Case Officer: Andrew Lewis**Recommendation:** Approve**Applicant:** Heyford Park Settlements LP**Proposal:** Reserved Matters to 13/01811/OUT - Dorchester Phase 5, comprising the provision of seven open market dwellings with associated landscaping, car parking, infrastructure and external works.**Expiry Date:** 19 July 2019**Extension of Time:** 13 September 2019

SCALE: 1:500 @ A3  
 DATE: DECEMBER 2018 DRAWING TITLE: REFUSE PLAN  
 DRAWN: DGK DRAWING NO: 0521-PH5C-5D-5(R)-111

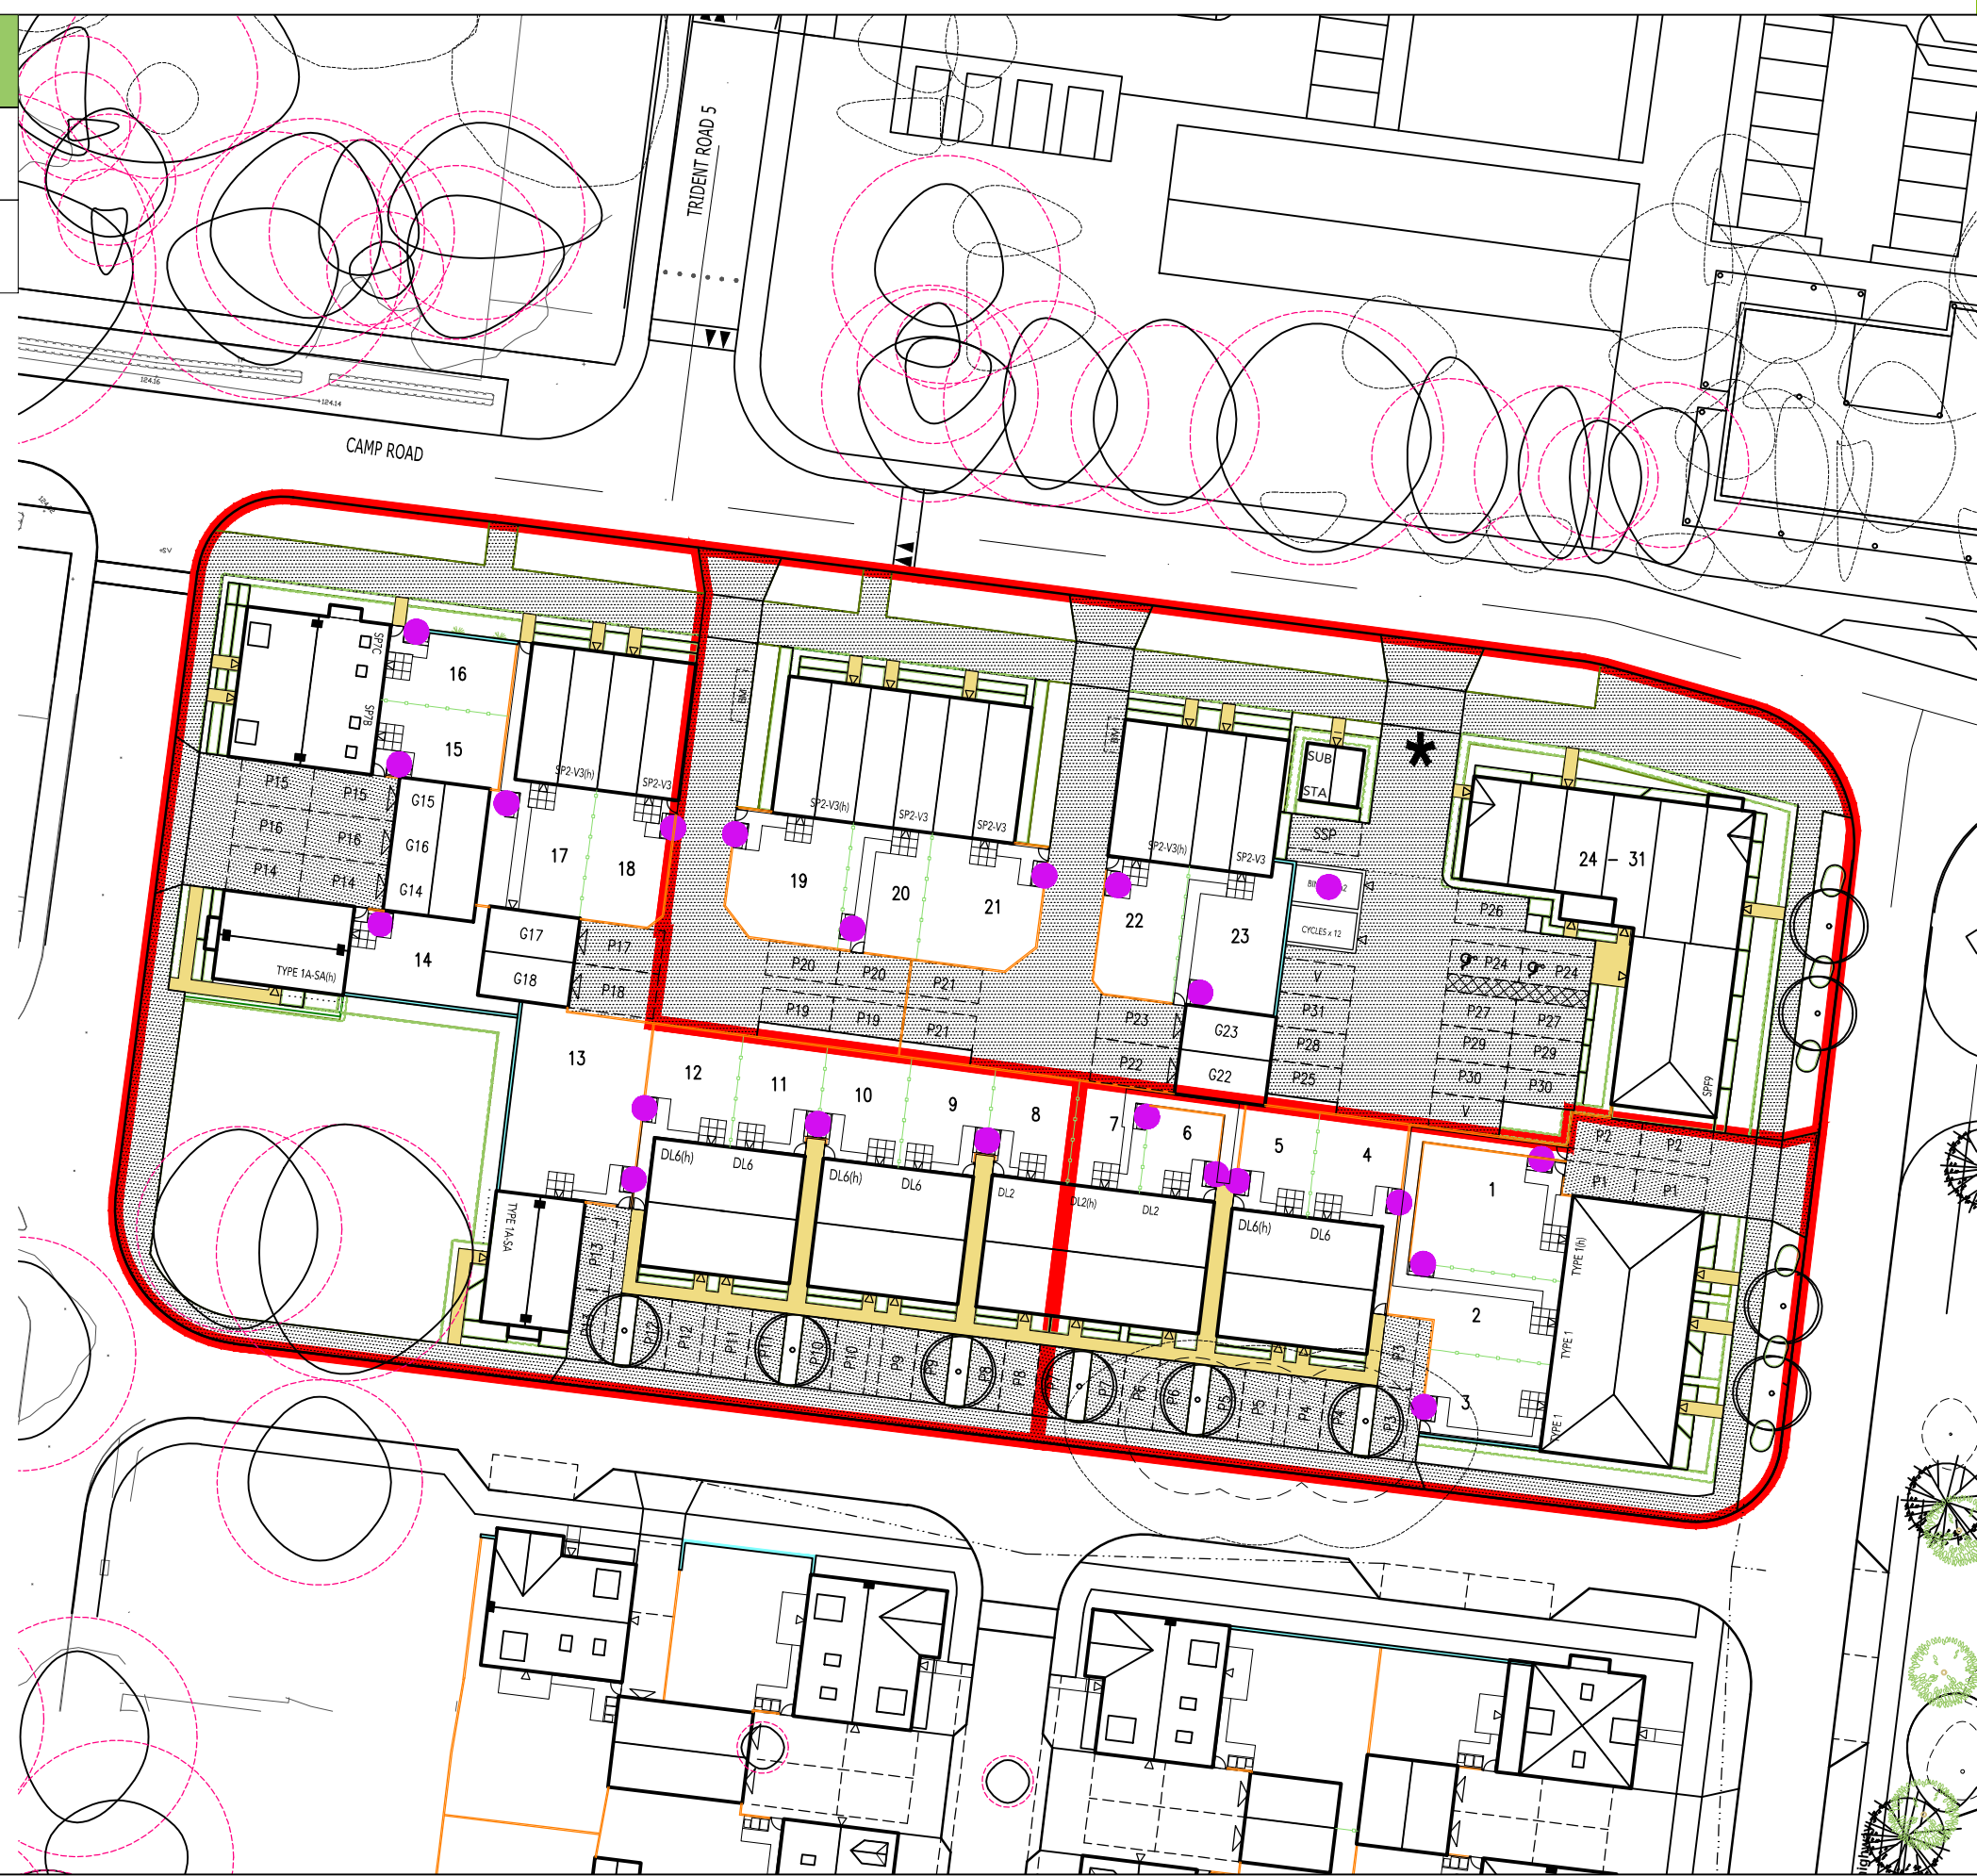
- 6.7. OXFORDSHIRE COUNTY COUNCIL (Highways)
- **Object** to absence of refuse vehicle swept path
 - Intensification of residential use at Heyford Park above the already permitted quotas will require the need for further transport impact analysis.

- In the event that permission is to be given, the following planning conditions should be attached:
 - D5 Vision Splay.
 - D10 Estate Accesses, Driveways and Turning Areas.
